COUNTY COUNCIL'S RESPONSE TO CONSULTATION ON THE FOLLOWING DEVELOPMENT PROPOSAL

Application no: 24/02058/F

Proposal: Full application for the proposed erection of a two storey building to form a 66 no. bedroom care home for older people with parking, access, landscaping and associated ground works.

Location: Land to the North of Anniversary Avenue, Graven Hill , Bicester, OX25 2BF

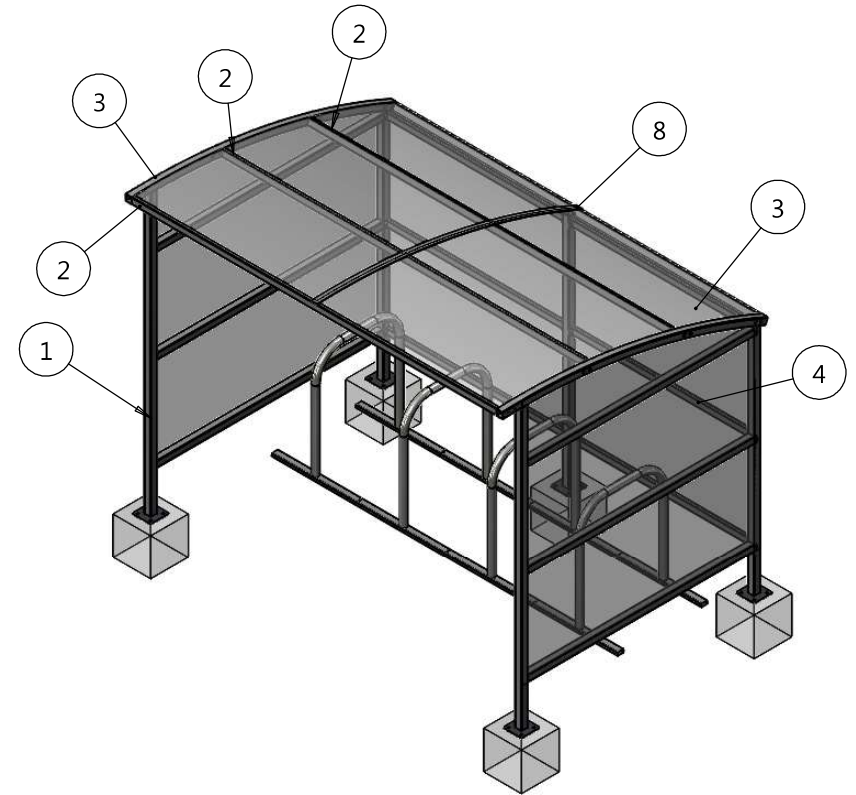
The other outstanding matter is with regards to insufficient cycle parking which is yet to be addressed. A pre-commencement planning condition will suffice in this case.

Prior to commencement of the development hereby approved, covered cycle parking facilities (with a minimum capacity of 16 bicycles) shall be provided on the site in accordance with details which shall be firstly submitted to and approved in writing by the Local Planning Authority. Thereafter, the covered cycle parking facilities shall be permanently retained and maintained for the parking of cycles in connection with the development.

TITLE
 PROPOSED SITE PLAN

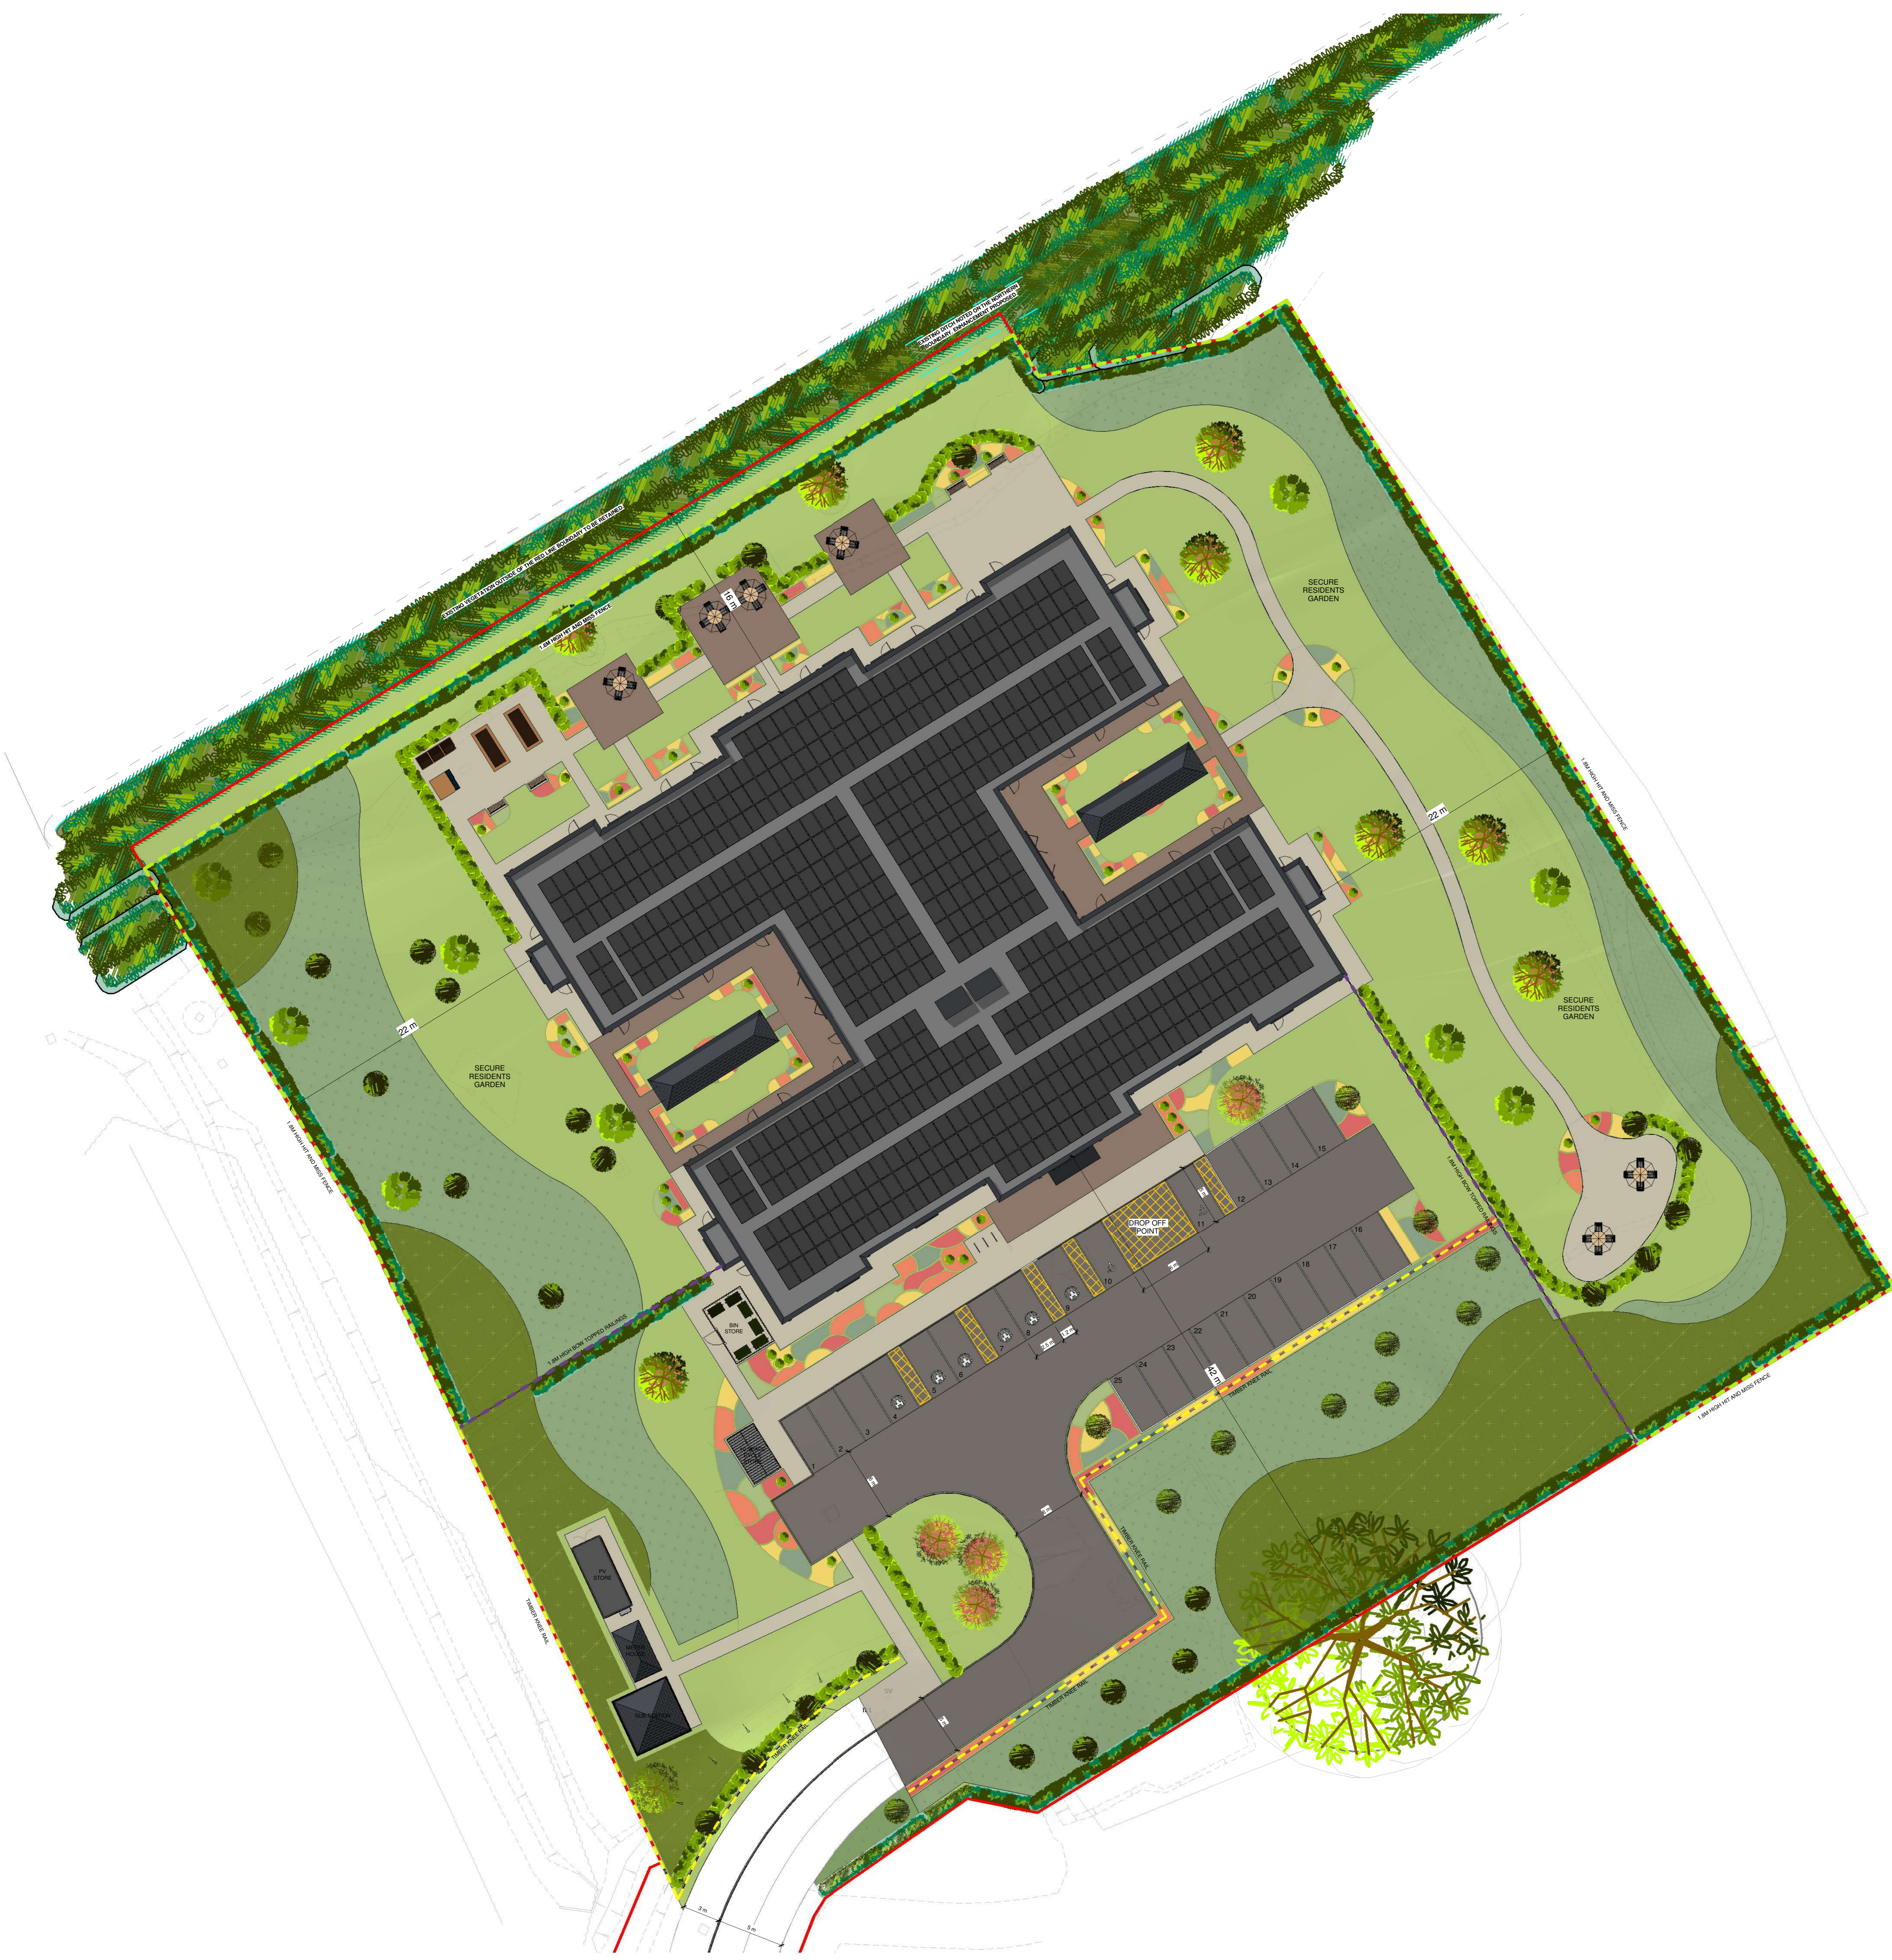
- A lack of access arrangement details including swept path analyses and
- Insufficient cycle parking provision

TITLE
Drainage Strategy

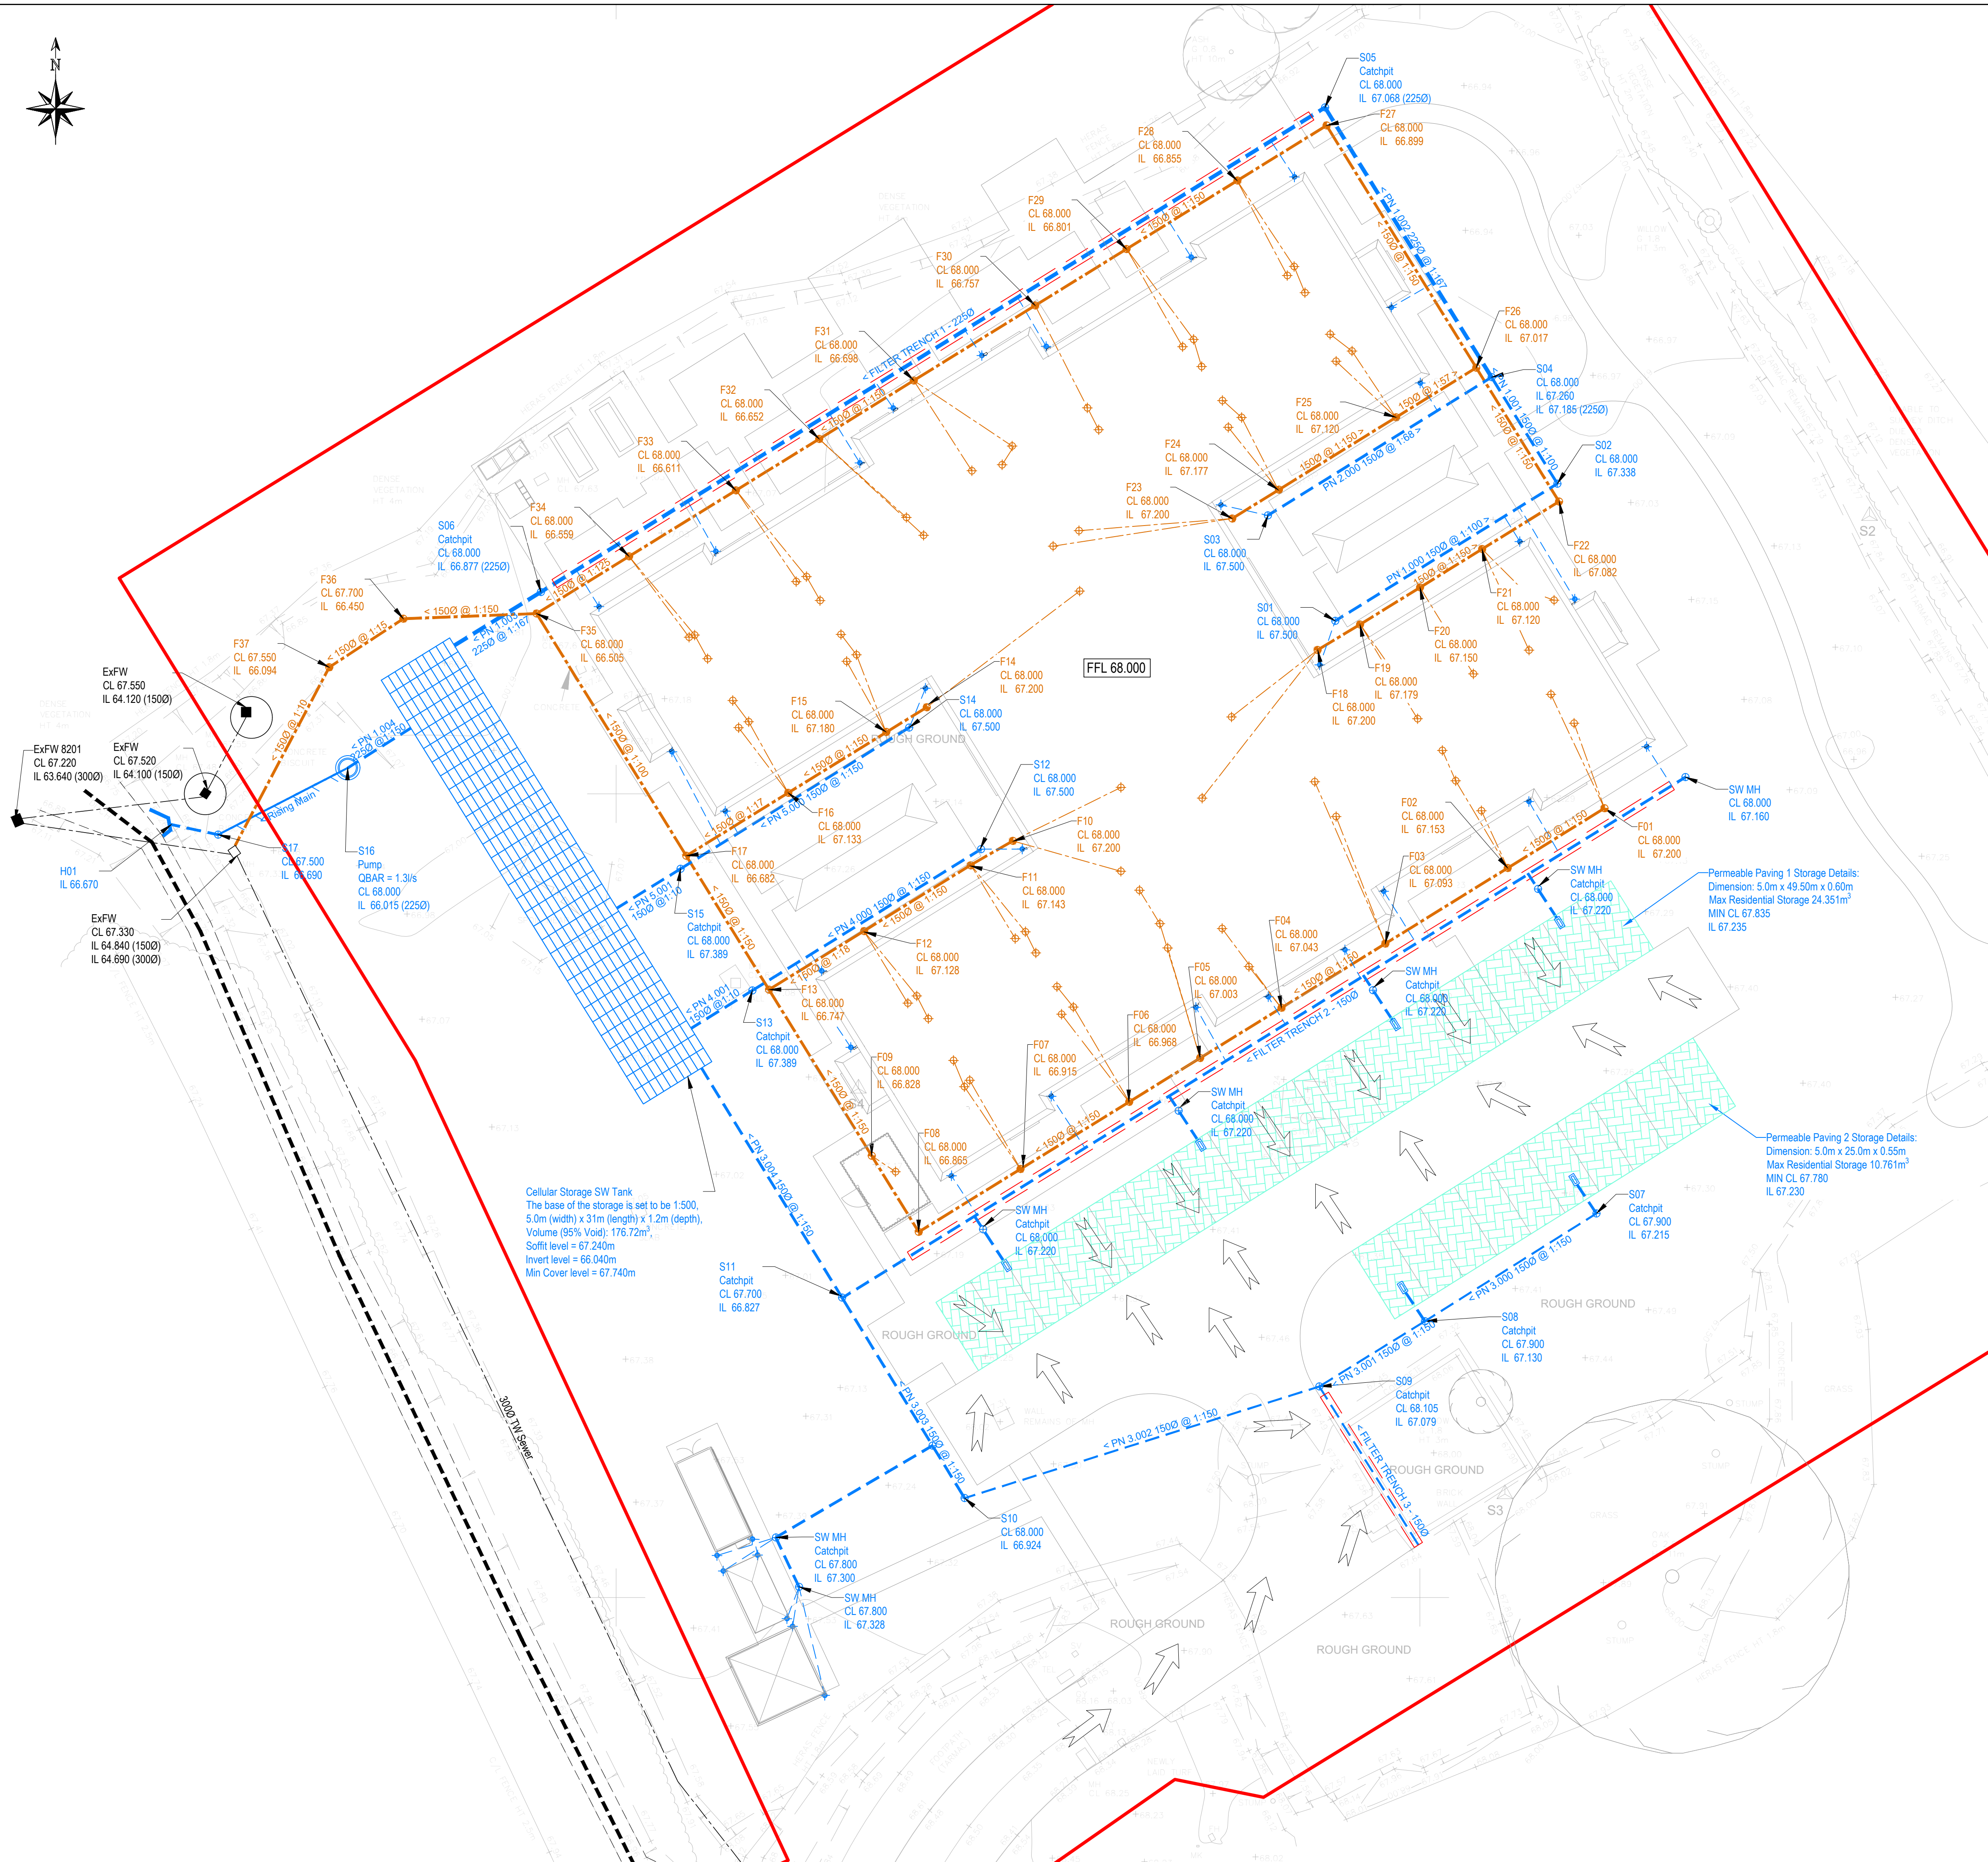
Missing surface water drainage information?

The LLFA previously requested details of how the allowable discharge rate has been calculated. It is important that this is based on the developable area rather than the whole site area.

The FRA has been revised to Issue 3. It is not clear whether there is a missing surface water drainage strategy document that would address our concerns. One does not appear to have been uploaded to the planning system.
